**KIRKLEES METROPOLITAN COUNCIL
INVESTMENT & REGENERATION SERVICE**

**DELEGATED DECISION TO DETERMINE PLANNING APPLICATIONS TO
CARRY OUT DEVELOPMENT WITHOUT COMPLIANCE WITH PLANNING
CONDITIONS PREVIOUSLY ATTACHED**

Reference No:	2025/70/91604/W
Site Address:	Huddersfield Bus Station, Upperhead Row, Huddersfield, HD1 2JN
Description:	Variation condition 2 (plans) on previous permission 2024/92302 for refurbishment comprising (phase 1): facade improvements including Henry Street entrance; replacement shop fronts; alterations to external bus apron; extension and alterations to existing barrier within the bus alighting lane adjacent to Henry Street; (phase 2): new entrance canopy; public realm improvements; cycle hub; facade improvements including replacement shop fronts
Recommending Officer:	Liz Chippendale

Application: 2025/91604

P1 Proposed Cycle Parking Plan
Scale: 1 : 50

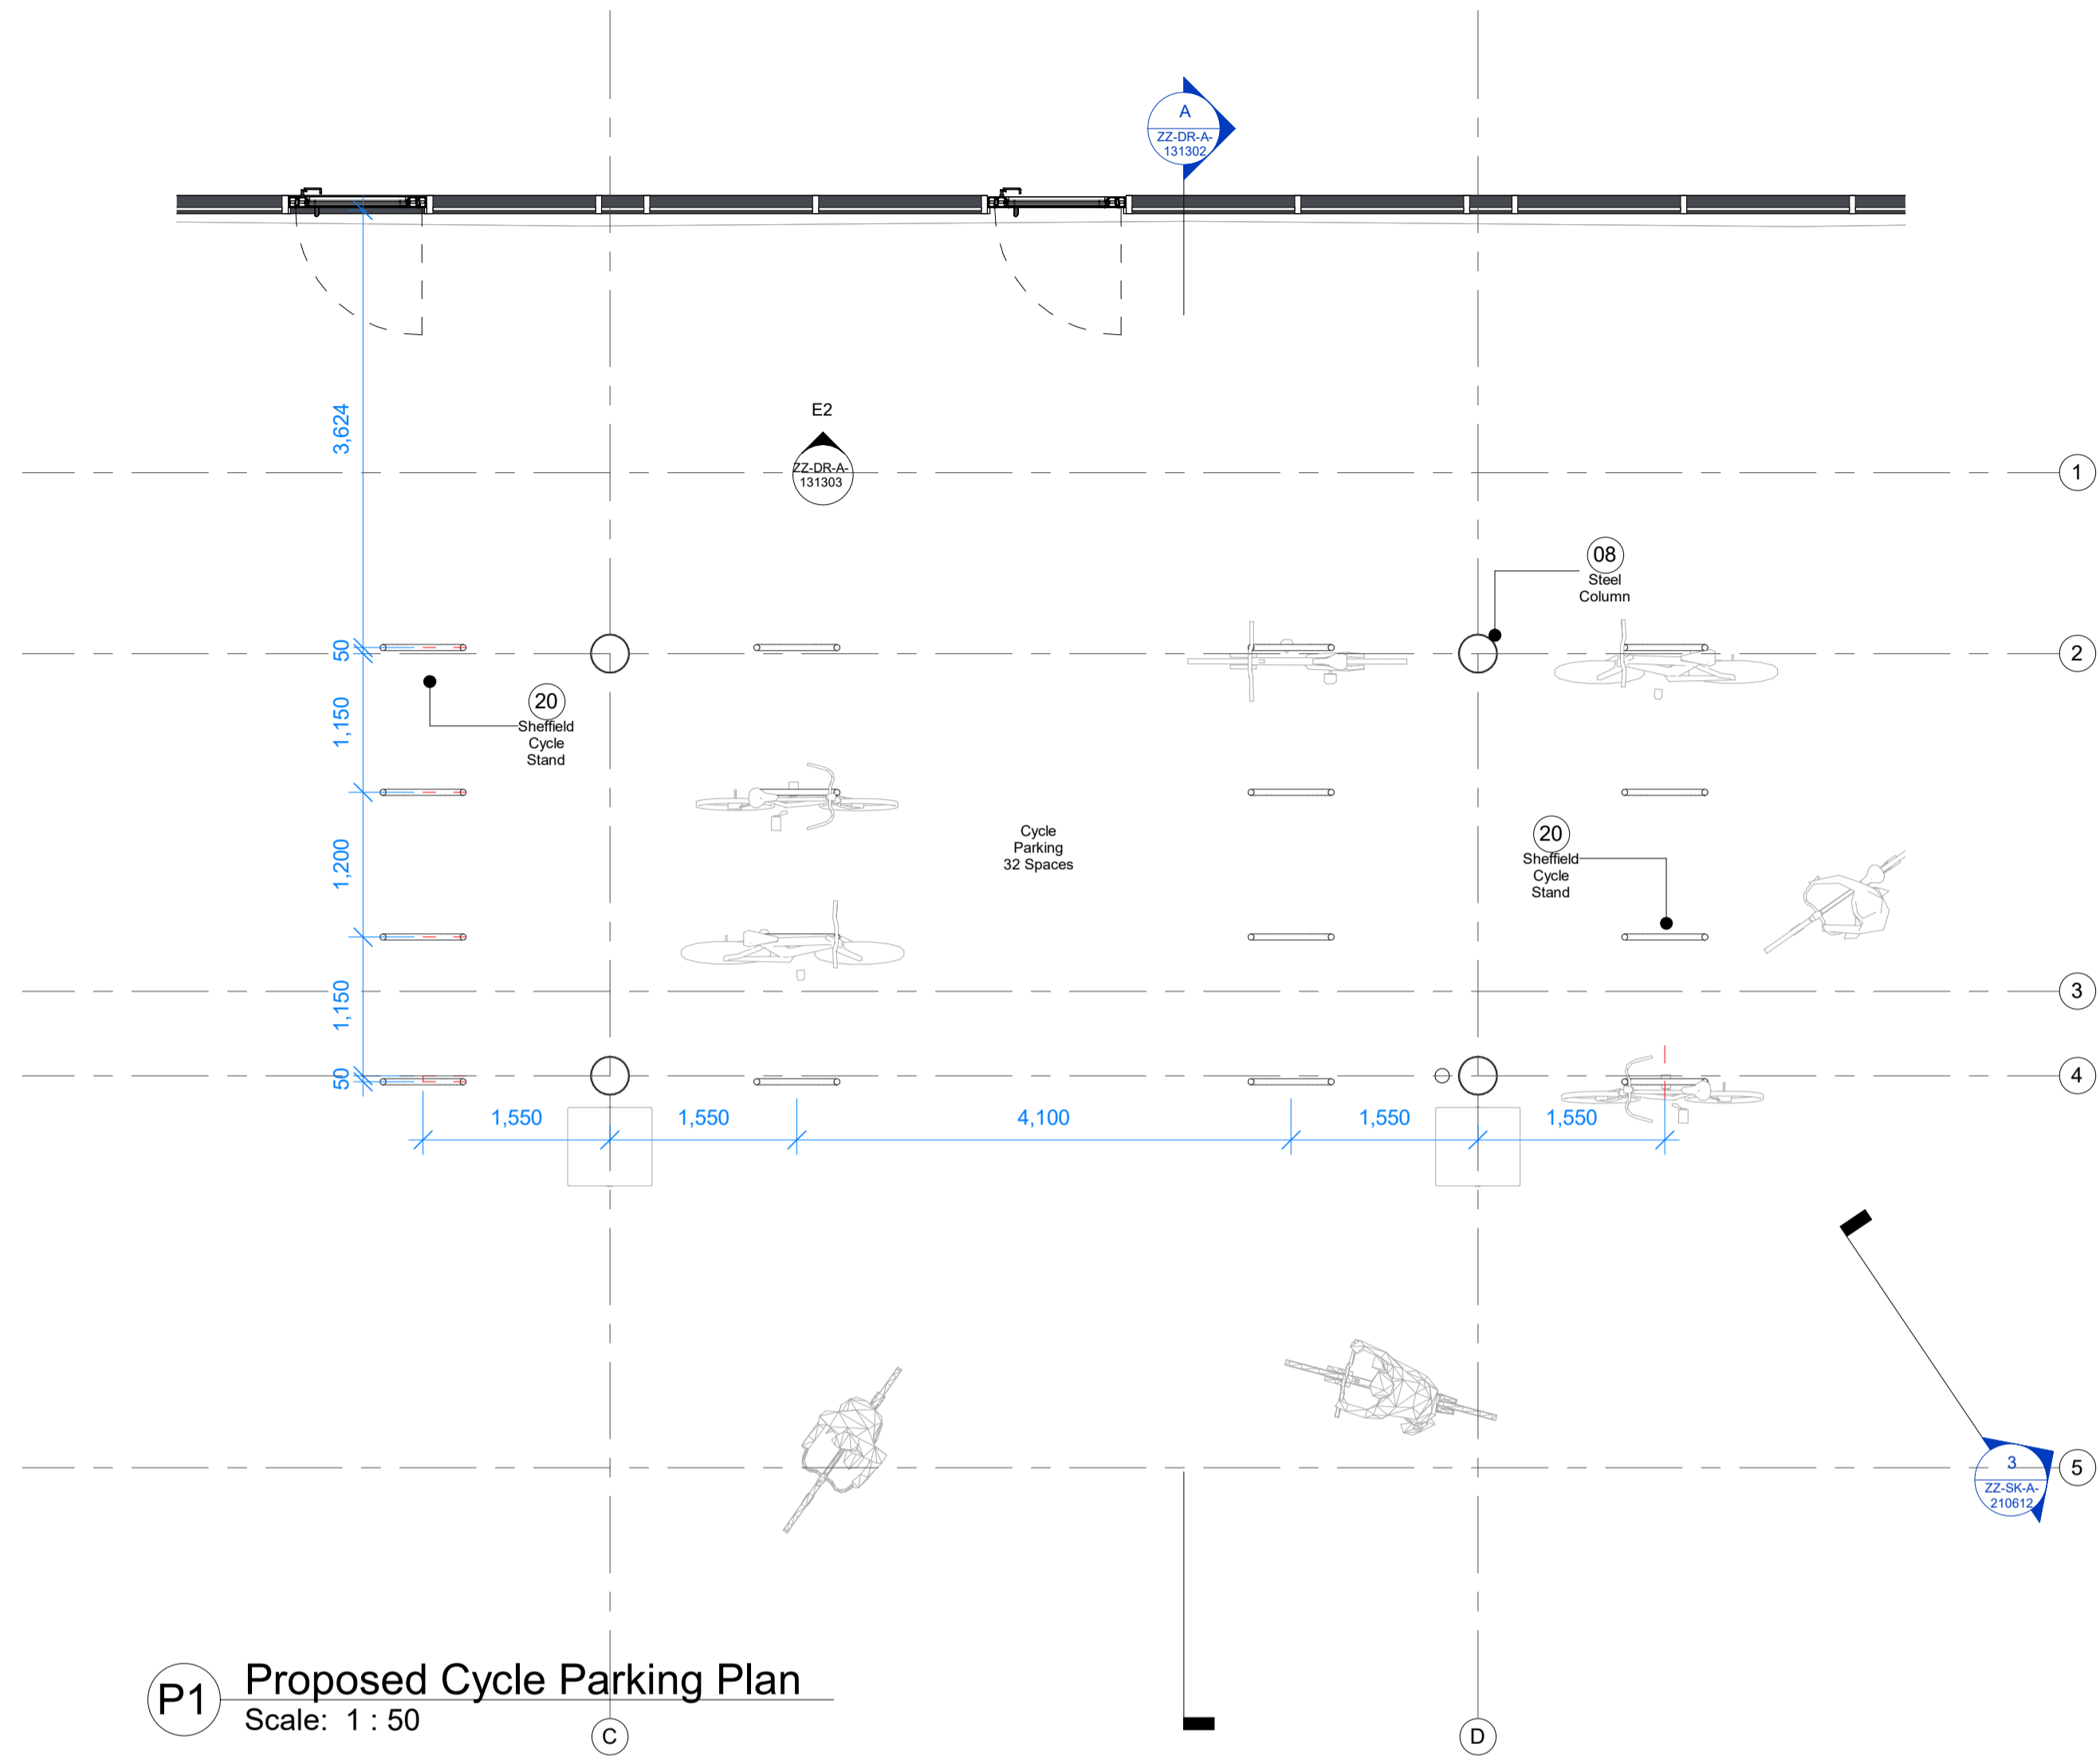
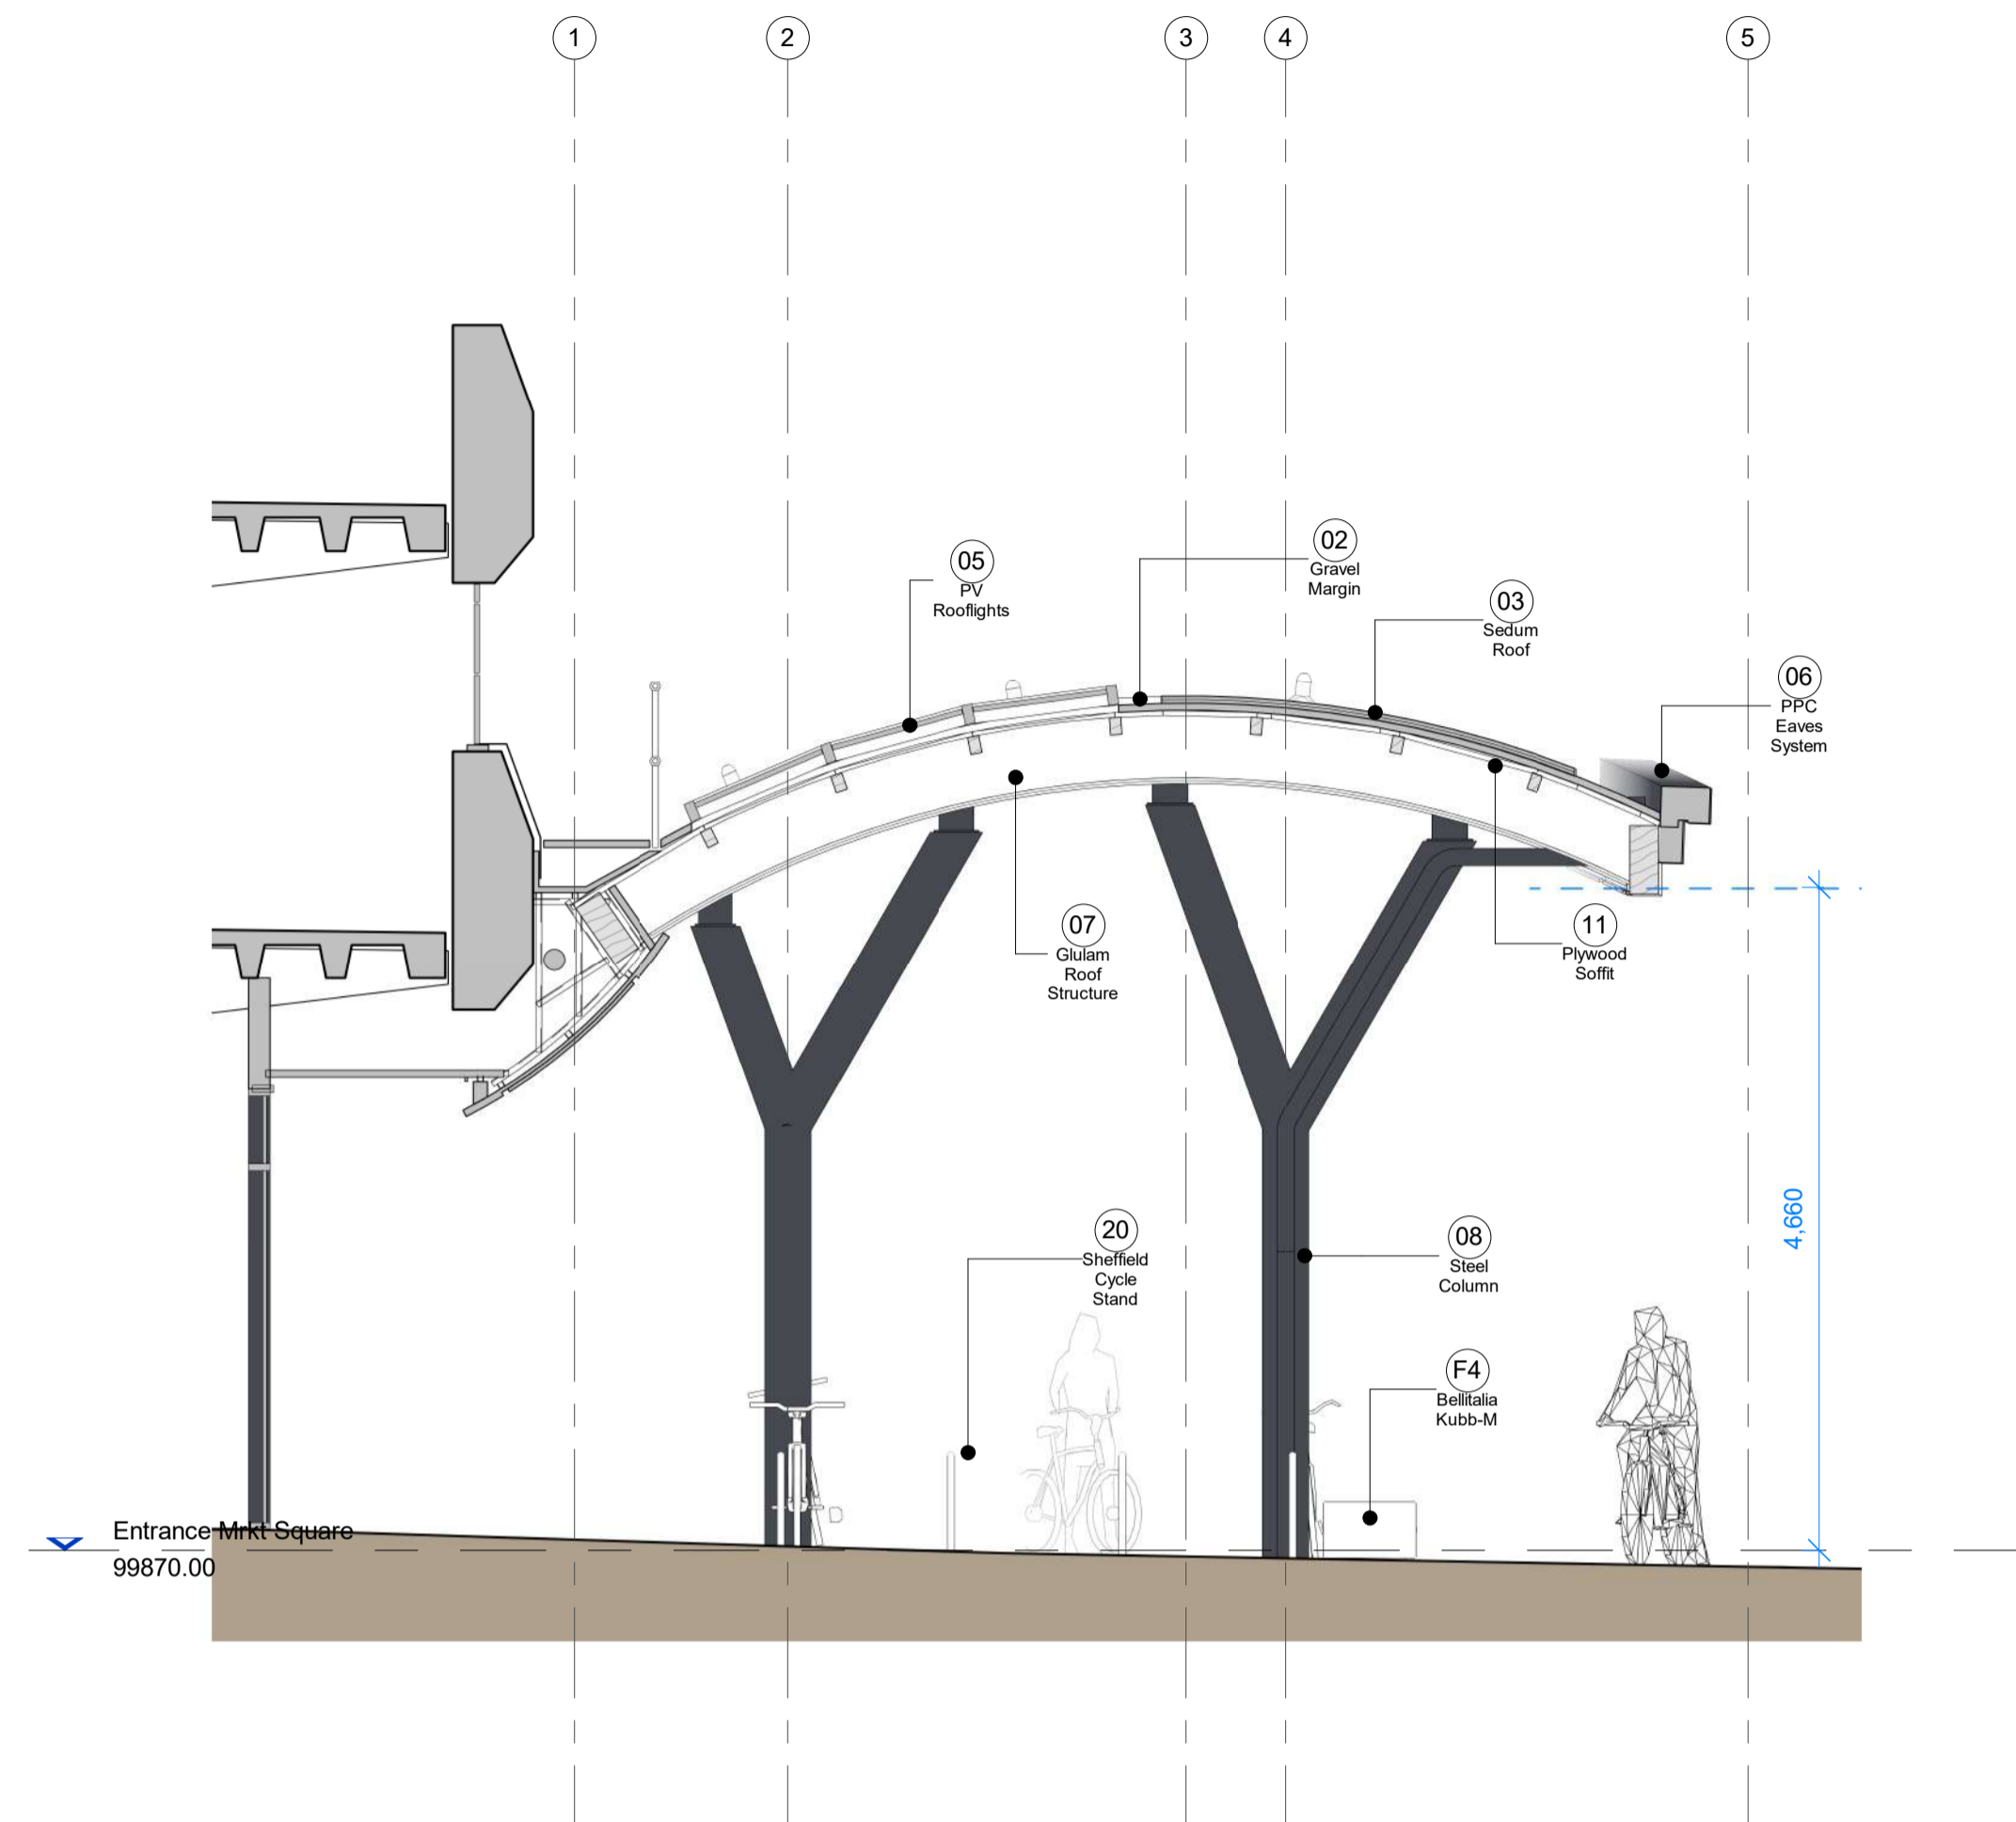
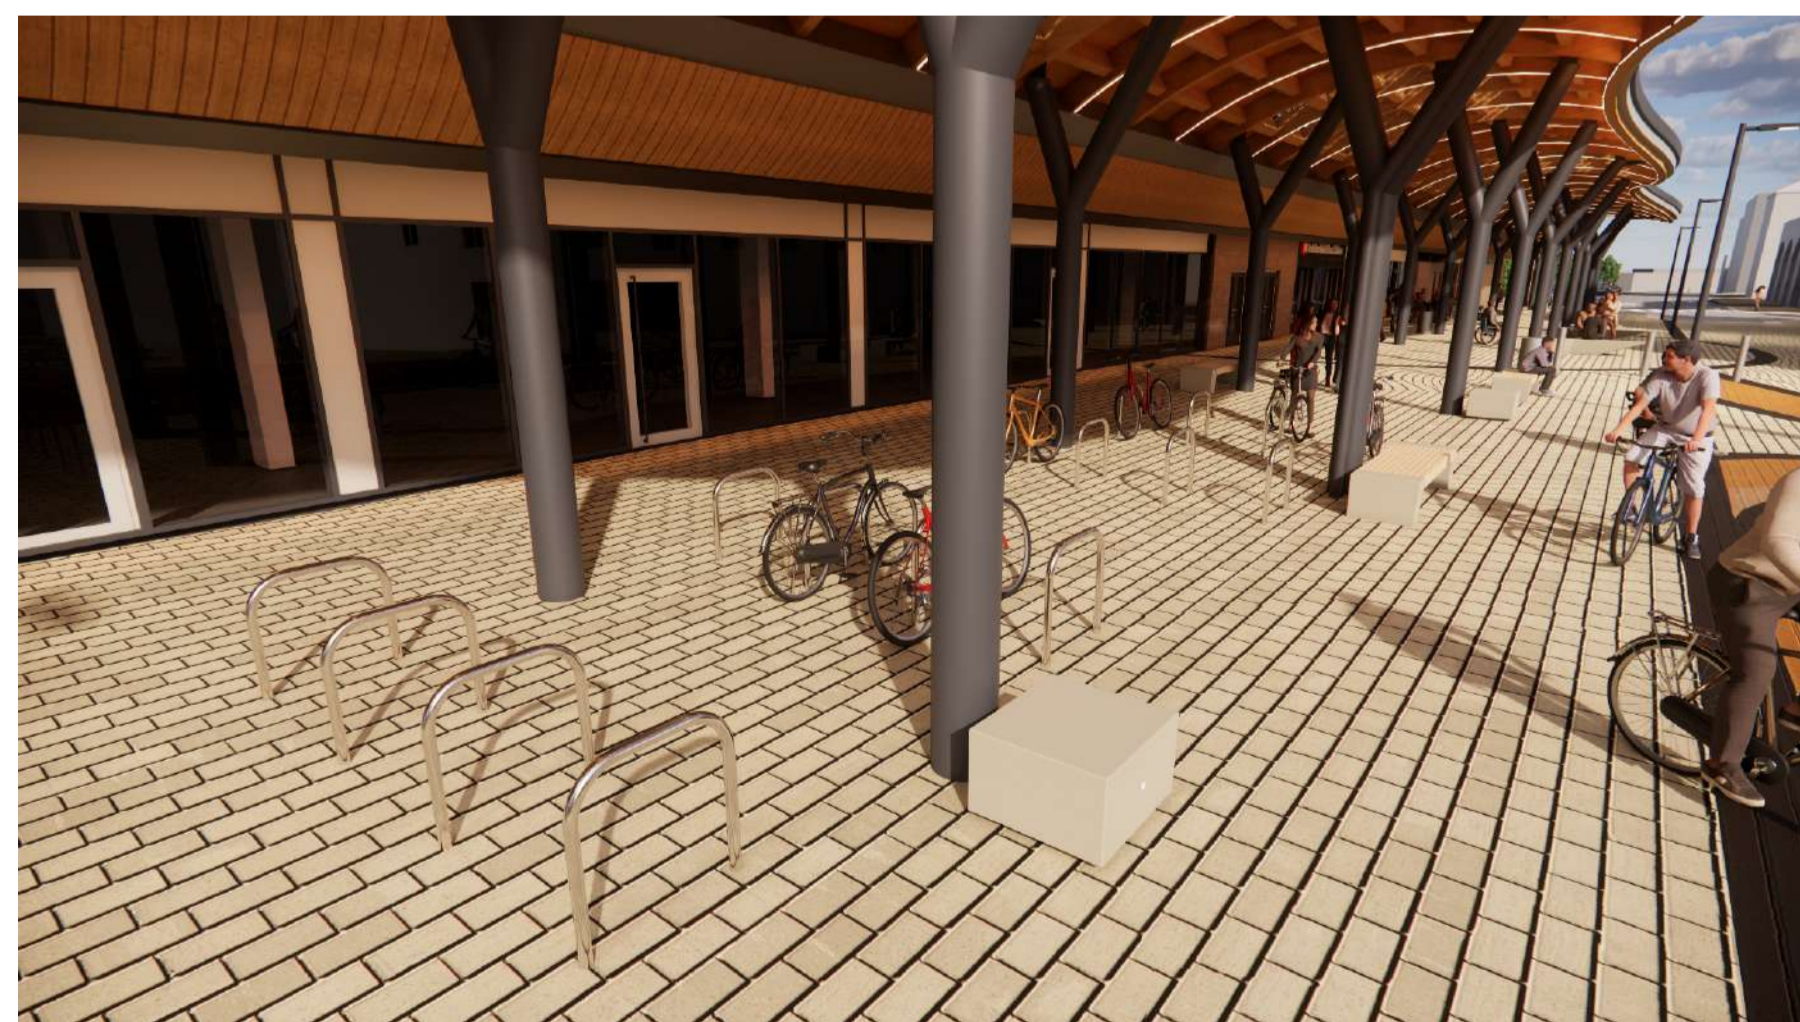
Description of Change 2: The proposed Cycle Hub and Bin Store have also been removed as a part of the Value Engineering process and replaced with a dedicated cycle parking area.

K.C. Highways (Development Management): *Officers are reluctant to see the approved cycle hub removed but have no objection to the proposed cycle stands.*

The approved cycle hub provided safe and secure cycle parking for users of the bus station and would have promoted active travel within the district by providing a link between cycling and public transport. The proposal removes the cycle hub and is replaced by 16 "Sheffield Stand" style hoops under the canopy. The proposed hoops are not as secure as the previously proposed hub storage and, even though they are under the canopy, they are still more open to adverse weather. KC Highway Officers consider the proposed cycle storage to be a lesser quality replacement for the previously proposed cycle hub as they do not provide the same level of secure long-term parking for cycles and would not appear as attractive to cycle users who may fear theft or vandalism with the hoops in this location.

While K.C. Highways' concerns are noted, the original design of the cycle hub was not necessary to make the development acceptable in planning terms. The proposed Sheffield stands, while perhaps to a lower standard, would still provide the same base function (i.e., the storage of cycles) that is required by planning. Given the overall improvements to the bus station and impact this will have on sustainable travel within the district, on balance, the proposed cycle stands are considered acceptable.

34. Notwithstanding condition 2, the hereby approved entrance canopy and cycle storage facilities shall be implemented in accordance with plans ref.

202335-SGP-ZZ-ZZ-DR-A- 131301 rev. P09 and 202335-SGP-ZZ-ZZ-DR-A-A-13000 rev P14.
